Traffic Management Plan

Project: new Sydney Fish Market Early Works

Rev C | Sept 2020

From: Kaye Russell <Kaye.Russell@transport.nsw.gov.au>
Sent: Wednesday, 19 August 2020 11:48 AM
To: Daniel Yarrow <D.Yarrow@hansenyuncken.com.au>
Subject: FW: new Sydney Fish Market - Early Works | Traffic Management Plan Consultation

Figure 6 - Traffic Control Plans for general operating site conditions at 1a, b & c Bridge Road

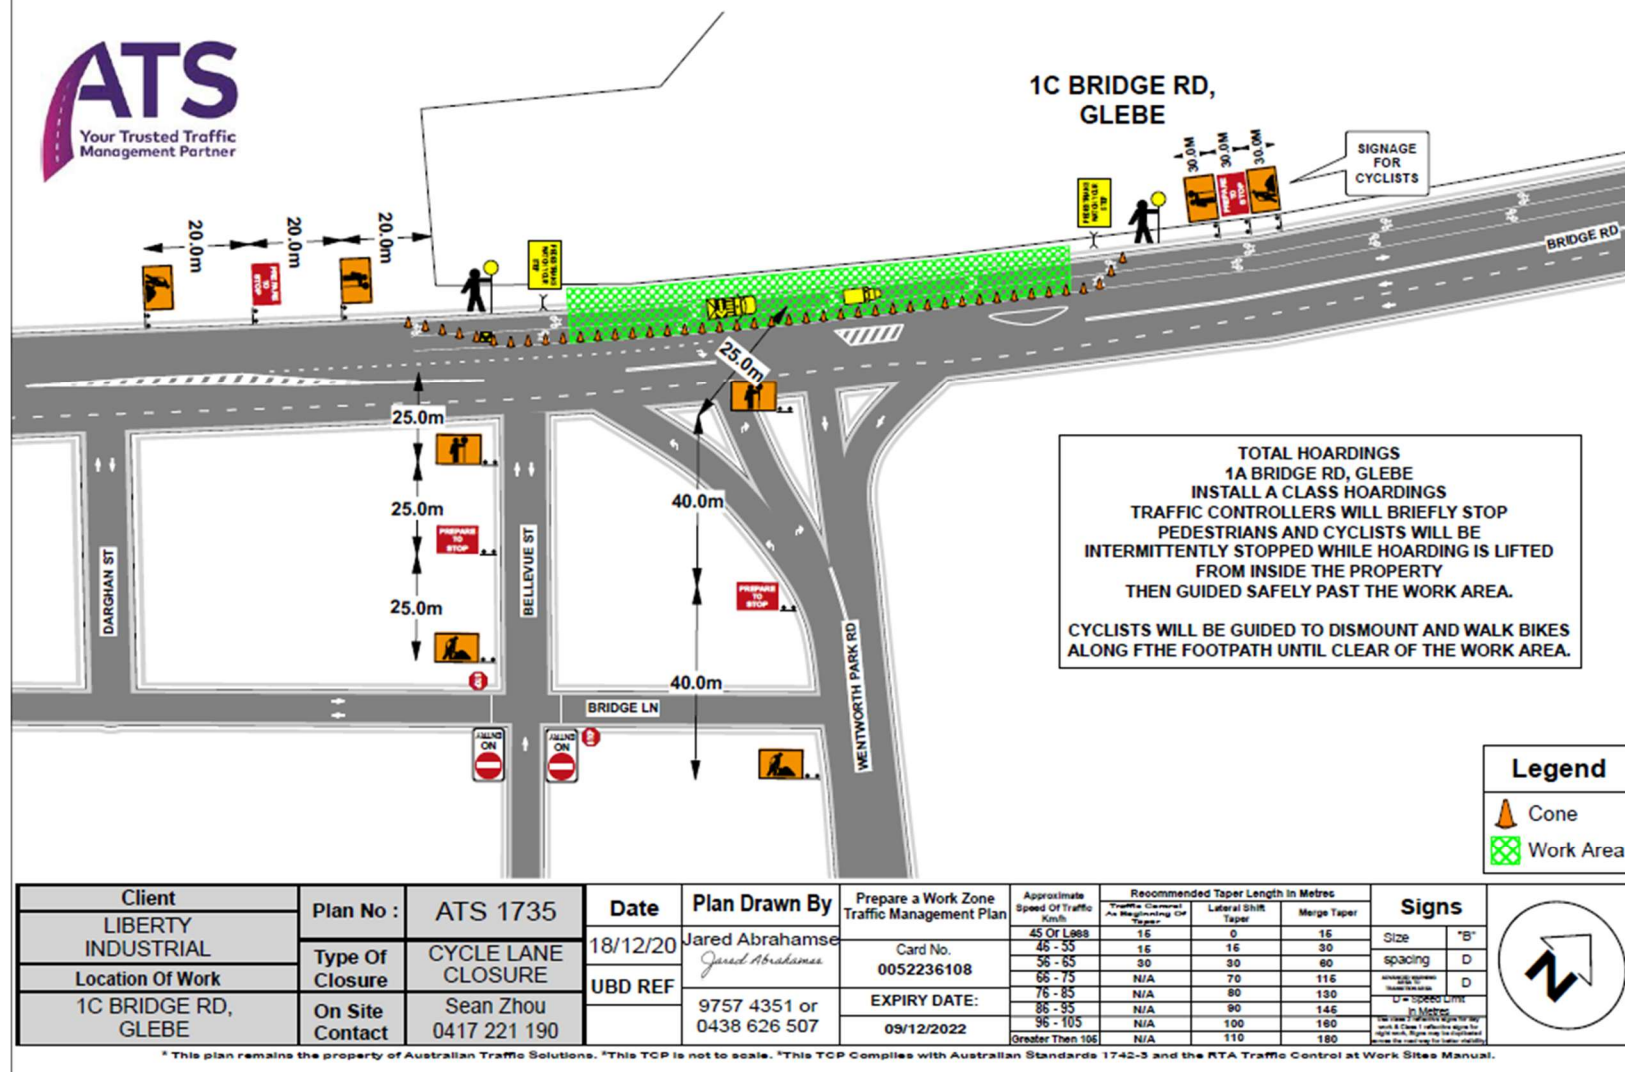
- City of Sydney Council and TfNSW have planned the installation of a pop-up cycleway along Bridge St to assist commuters to safely travel during Covid 19 restrictions. The date of installation is yet to be confirmed but as you can see from the attached plan the route will travel along the frontage of your site. The cycleway along the development frontage will not include any klem-flex devices and therefore will not impact or egress from the site. However measures should be taken to ensure safety of cyclists using the facility.

- Traffic controllers present at vehicle crossover points will need to manage interactions with pedestrians and cyclists.

Comments	Action
Traffic controllers present at vehicle crossover points will need to manage interactions with pedestrians and cyclists.	Liberty plan Section 3.6 updated to include
